Traffic Impact Study

To: Bill Guman, William Guman and Associates, LTD
From: Eli Farney, PE, PTOE
Date: July 23, 2024

BOCES Campus El Paso County, Colorado

Please include project
No. PPR2426

Figure 2 - 2024 Existing Traffic Volumes and Lane Geometry

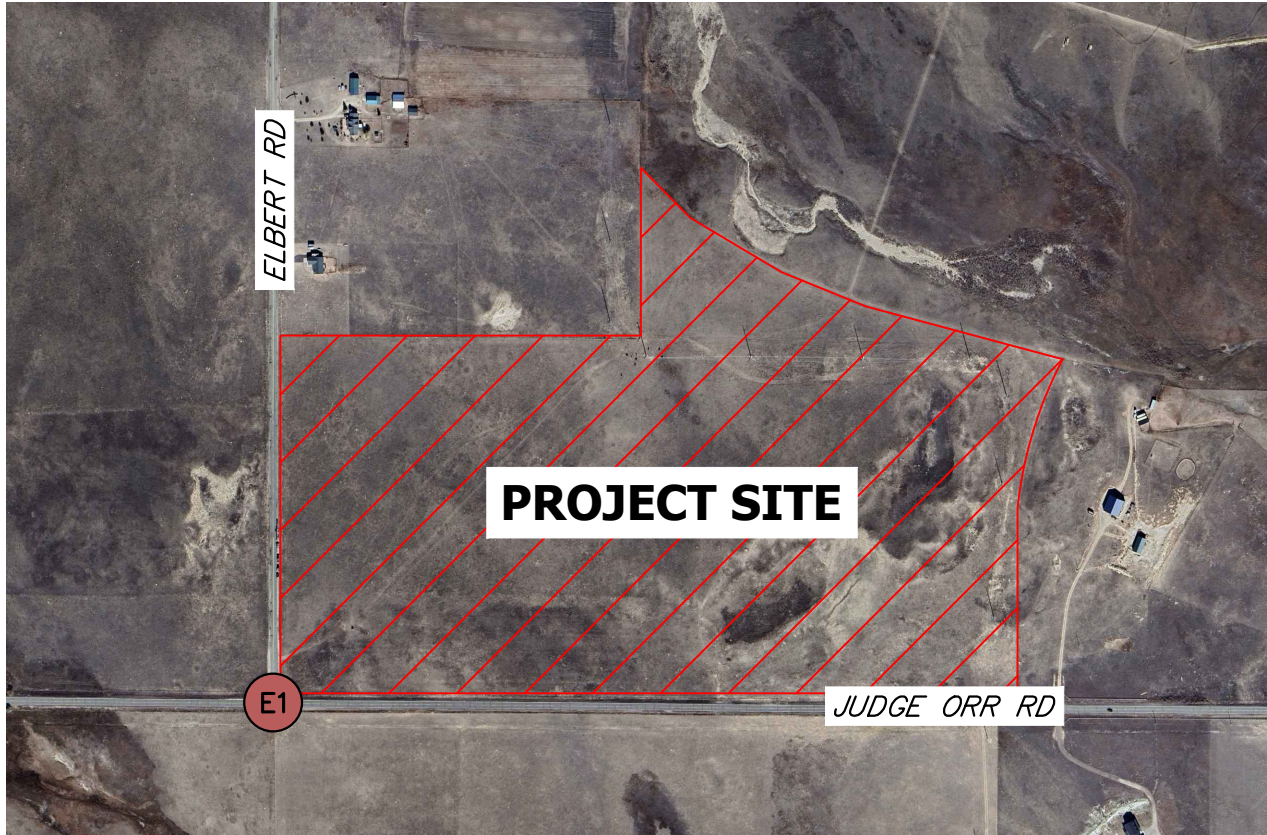
Please add a legend for AM/PM weekday peak-hour traffic (vehicles per hour) to all figures.

Please provide ADT values on each of the figures per ECM app. B.8

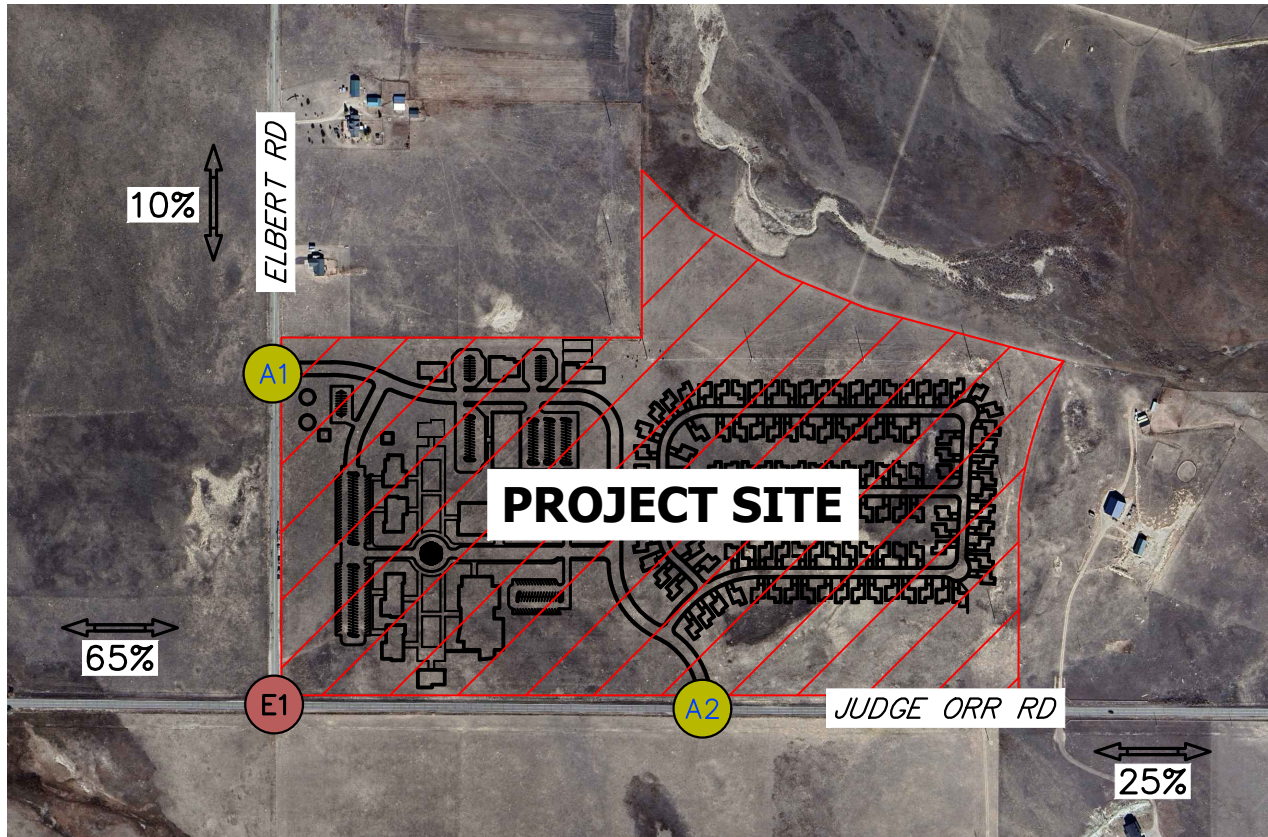
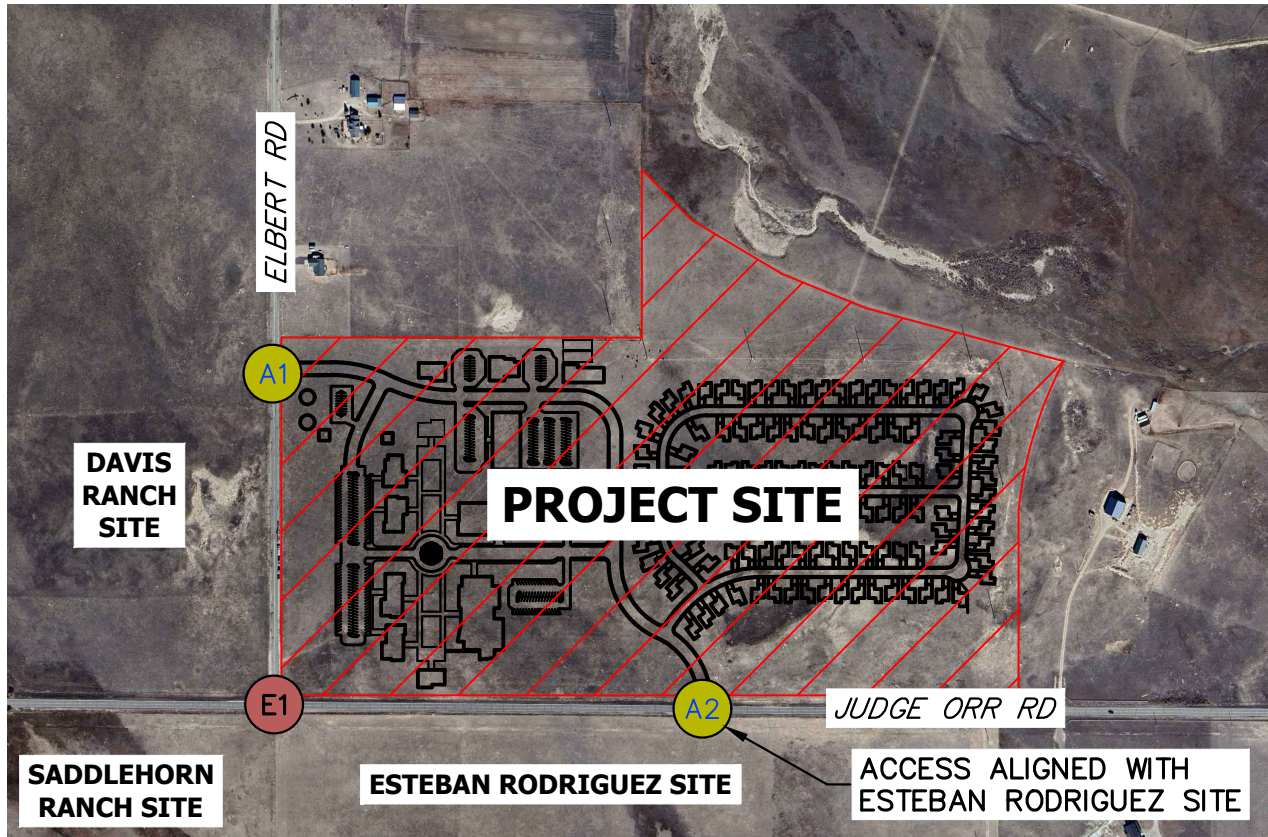
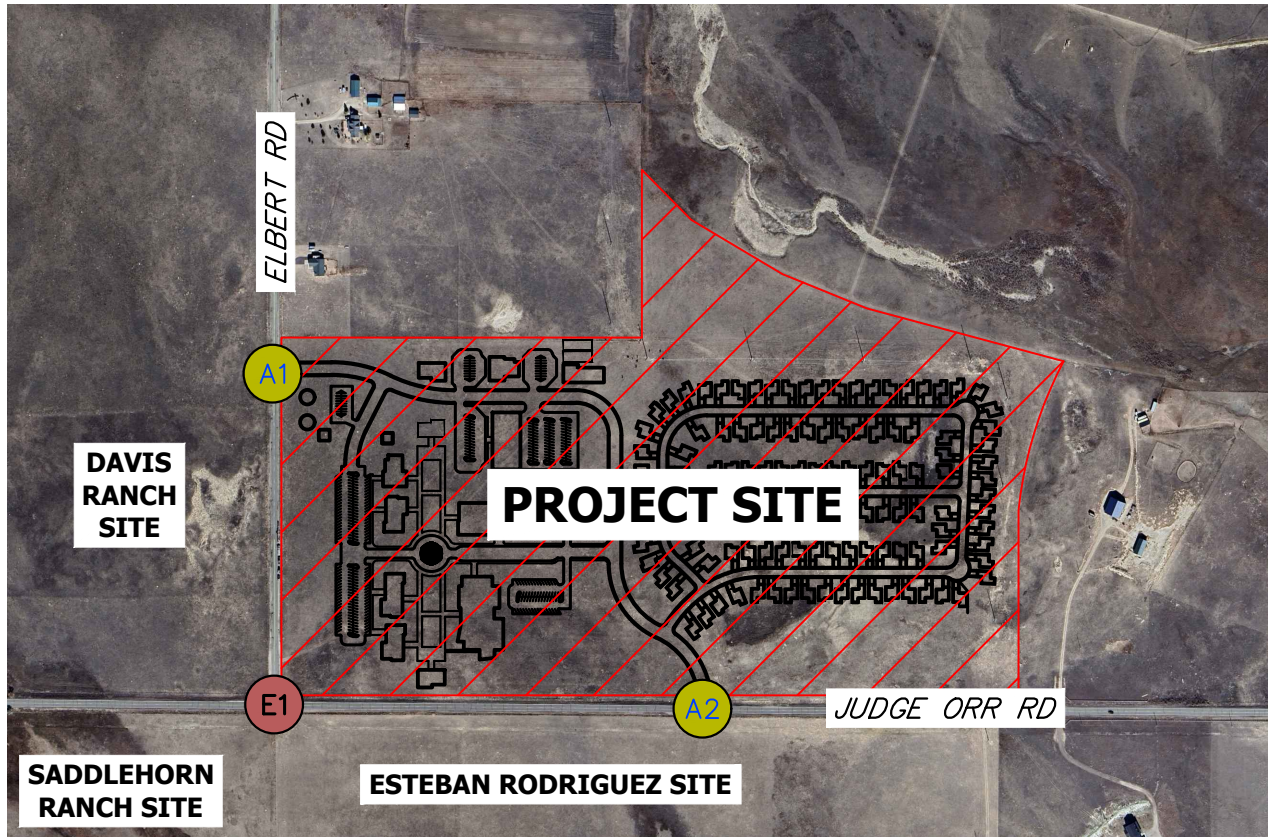
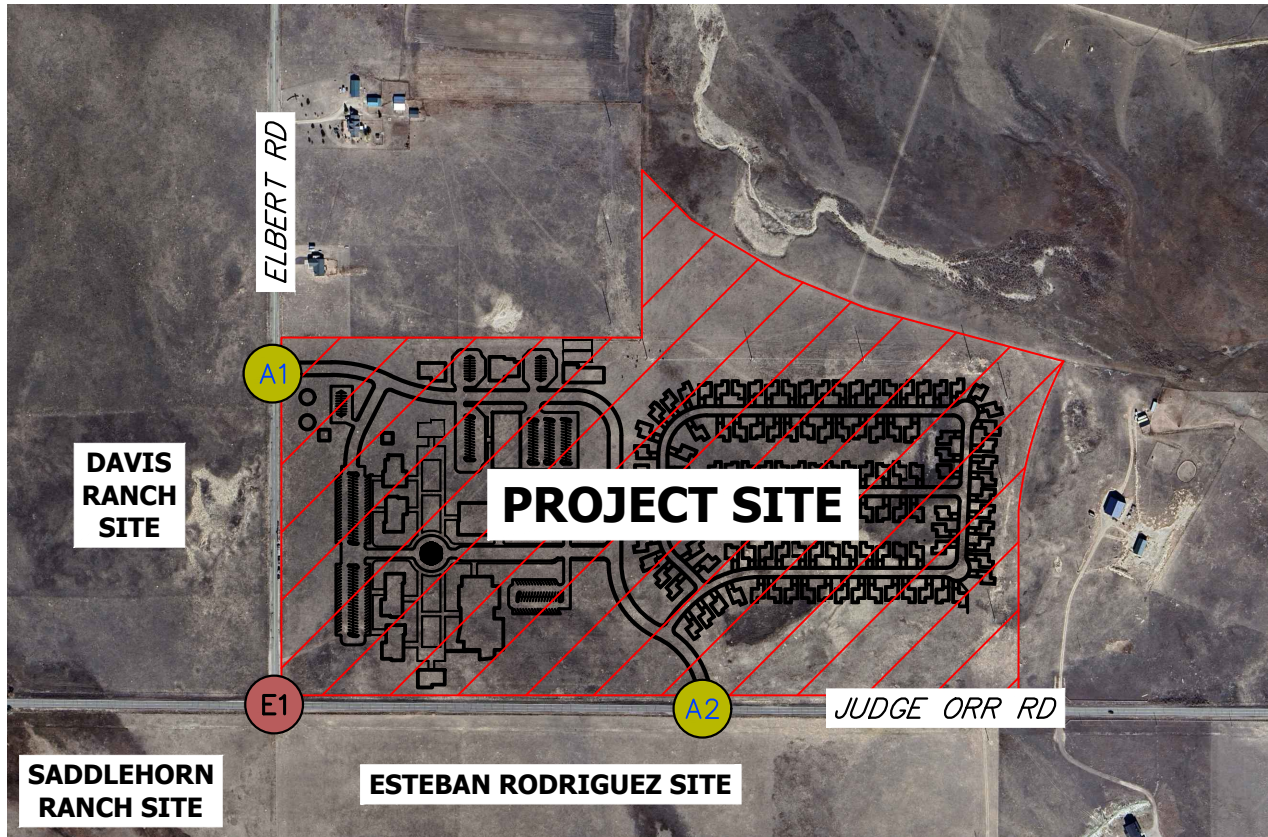
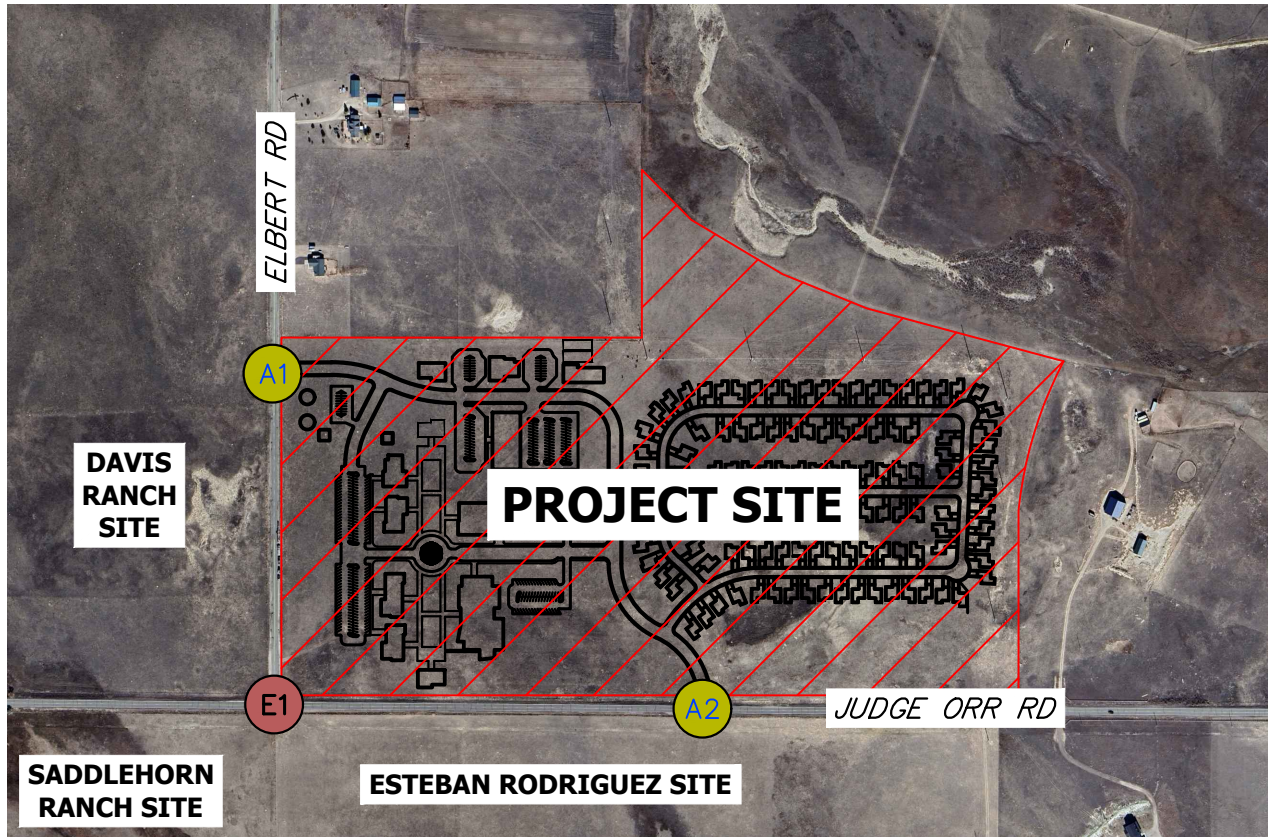
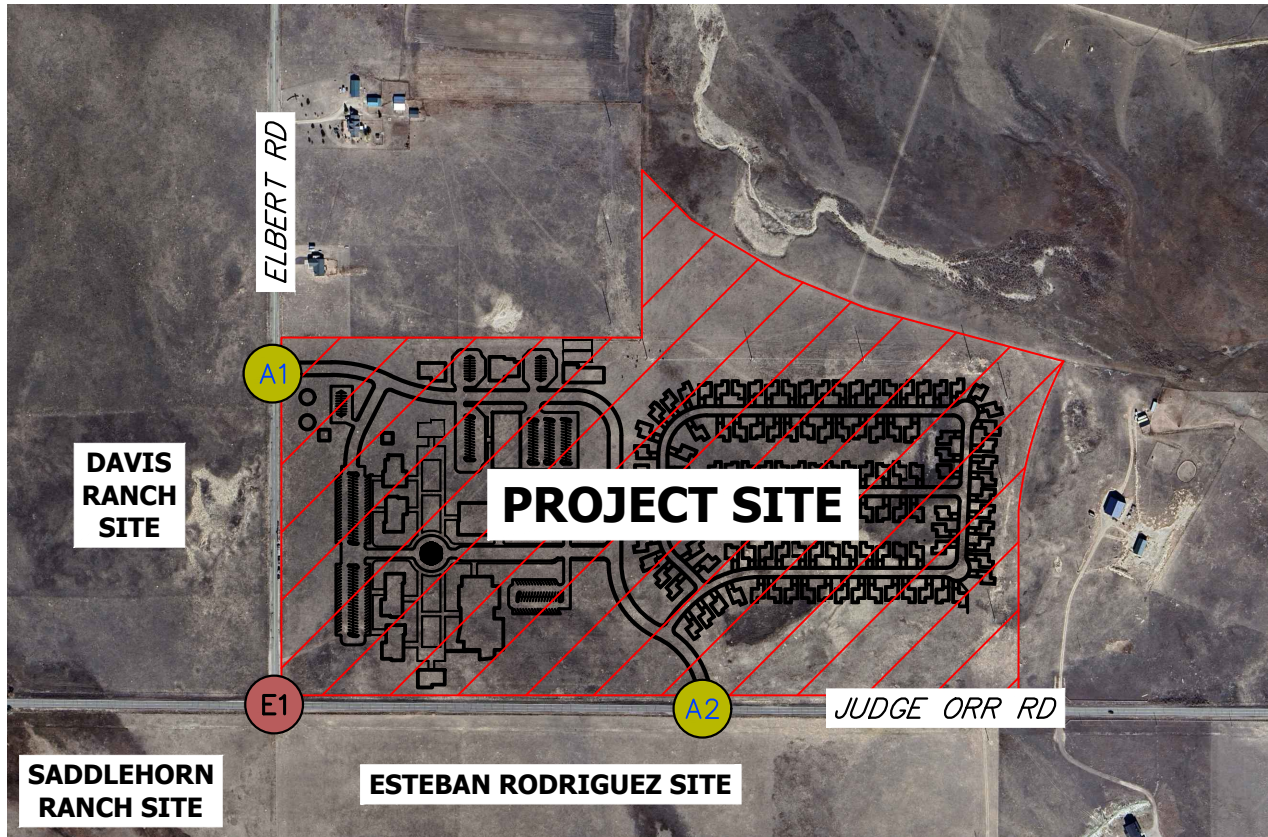
Please indicate whether any capacity improvements are needed. Comments have been provided in the figures to provided ADT for each of the roadways. It is anticipated that roadway widening along the property frontage may be needed as was required of Saddlehorn project.
